Our Ref: 405062_LEO_038.doc

17 July 2007

**PROPOSED DREDGING OF OYSTER LEASE AND OPERATION OF SAND STOCKPILE –
OYSTER LEASE # 80-178 AND LOTS 59, 101, 123, 124, 125 DP 753207, LOT 12 DP 816473,
2 – 6 RODMAY ST, TUNCURRY – PROVISION OF ADDITIONAL INFORMATION ON
AMENDED PIPELINE ROUTE**

Figure 3: Random Sampling
 Sites along proposed
 Dredge Pipeline Route

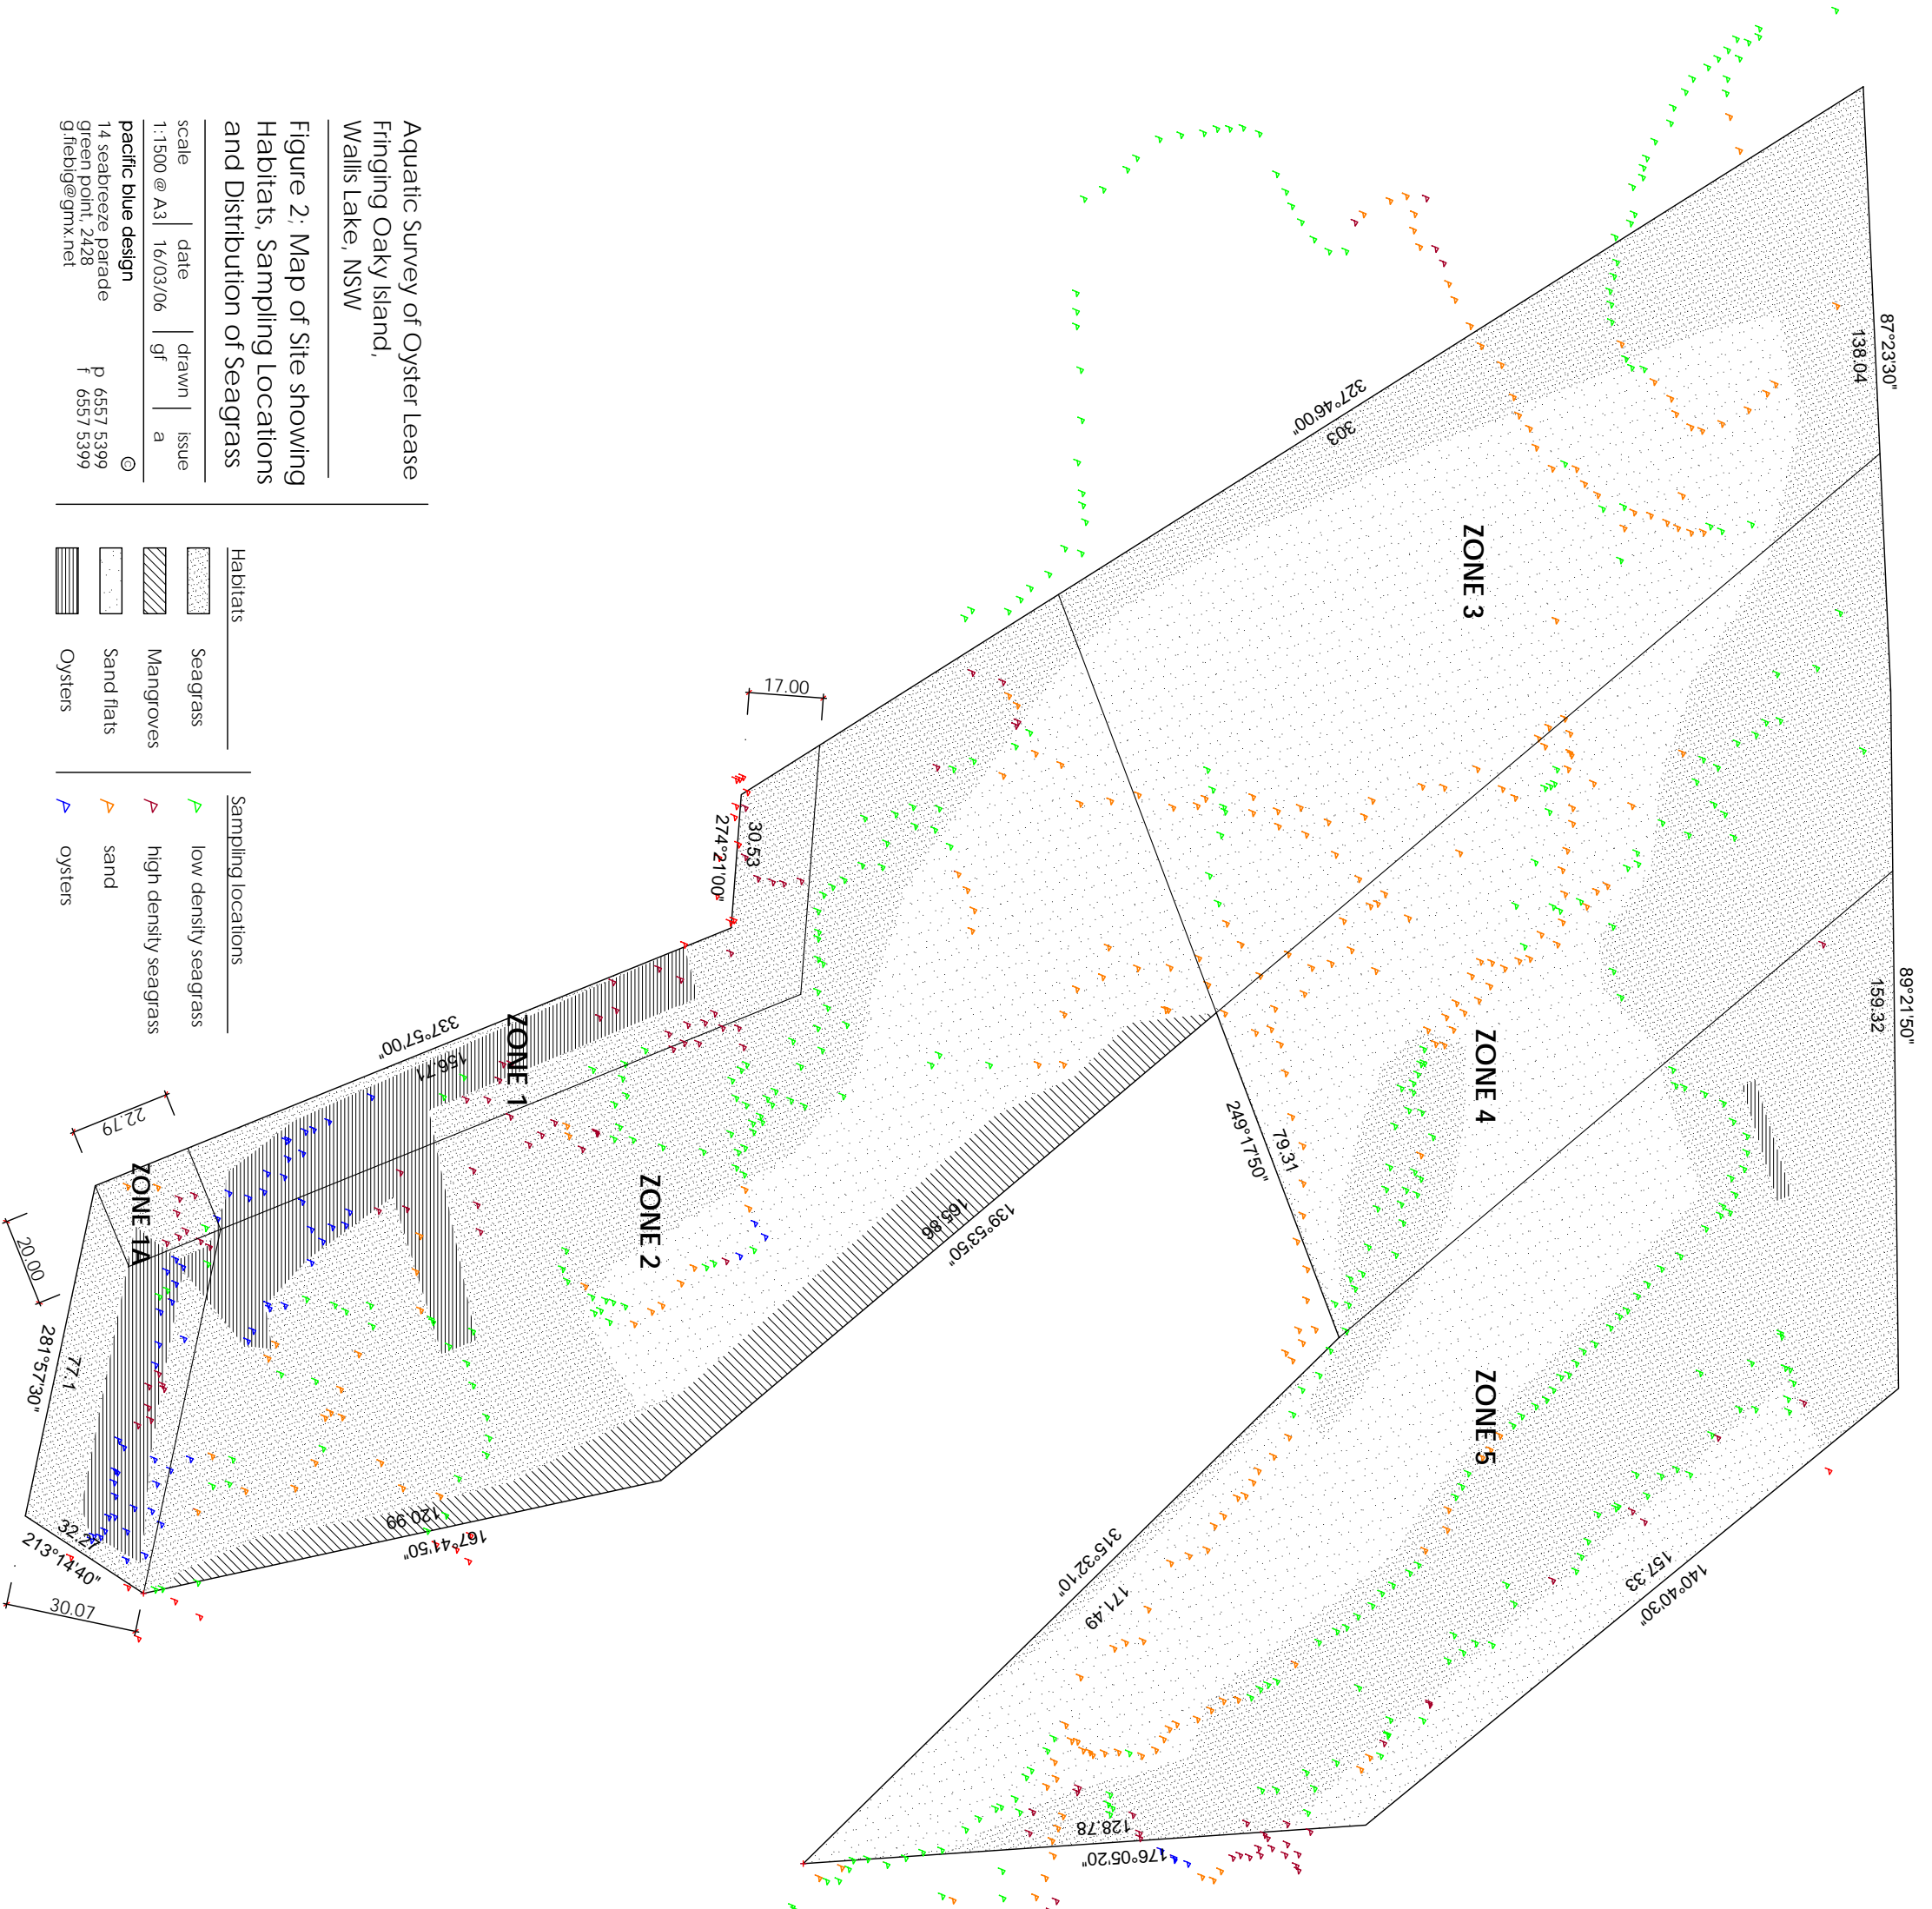
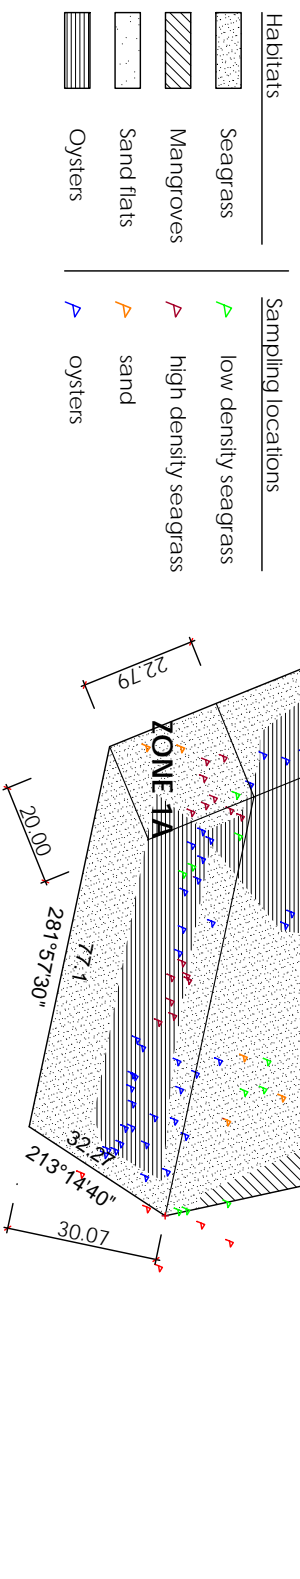
The exact route of the proposed pipeline and a description of its location with respect to tidal limits

A more-detailed description of the submerged benthic communities along the revised pipeline route and the likely impacts on these of the pipeline

Opportunities to straighten the 3x angled section of the route in the north (ie to either a curved alignment across the cleared land, or else extending the submarine section further north to align with the east-west section).

The route of the pipeline was provided in a map attached to our previous correspondence of 11 July 2007. With respect to its 'exact' location, the pipe will be submerged in shallow water (up to 1.3 m depth), within a variable distance of the shoreline, given that there are areas of the bed that are deeper than others. In general, the pipeline will be within 30 – 40 m of the river bank, with the alignment of the pipe being kept as straight as possible, to reduce pipe length. As there is no detailed hydro-survey of the pipeline route in this area of the river, the position as plotted on the map is approximate. It is therefore not possible to provide the exact final location of the pipeline, which will be determined as it is laid in the field at time of commissioning. It is the intention, however, to locate the pipeline in the approximate position indicated on the map. Notwithstanding, based on field investigations, the pipe will be placed at a depth below the level of low tide. The pipeline will therefore be permanently inundated with water.

The benthos along the amended section of the pipeline route is characterised by a patchy, sparse distribution of seagrass (*Zostera* and *Halophila* sp.), which is dependent on depth and light penetration of the water, and softness and depth of substrata. The amount of seagrass coverage in this section of the pipeline route varied from approximately 20 – 30 % cover down to zero cover. In general, however, the majority of the pipeline route in this area is devoid of seagrass. This is due to the stagnant nature of the water in this section of the river, which is on the opposite side of the river to the main flow channel (western side) and being located on the inside of a broad bend on the river. Tidal and river flow velocities are consequently very low, resulting in conditions (low nutrient, relatively high turbidity) that are not conducive to seagrass growth. The entire length of this section of the pipeline route is quite shallow, with maximum depths of approximately 1.3 m, though more generally 0.5 – 1 m. Water clarity in this section of the Wallamba River is low due to high suspended sediment loads, most likely entrained by wind-wave stirring given the large fetch to the prevailing southerly winds.

The 'right angles' in the pipeline are not literally right angles, rather, they have been drawn that way schematically. There is a minimum curve radius for the pipeline of several metres which will allow it to curve around corners or bends within the alignment which the pipeline follows. Therefore, the change in direction is not an issue operationally. There is therefore no need to amend the pipeline route over and above what has been suggested as an amendment.
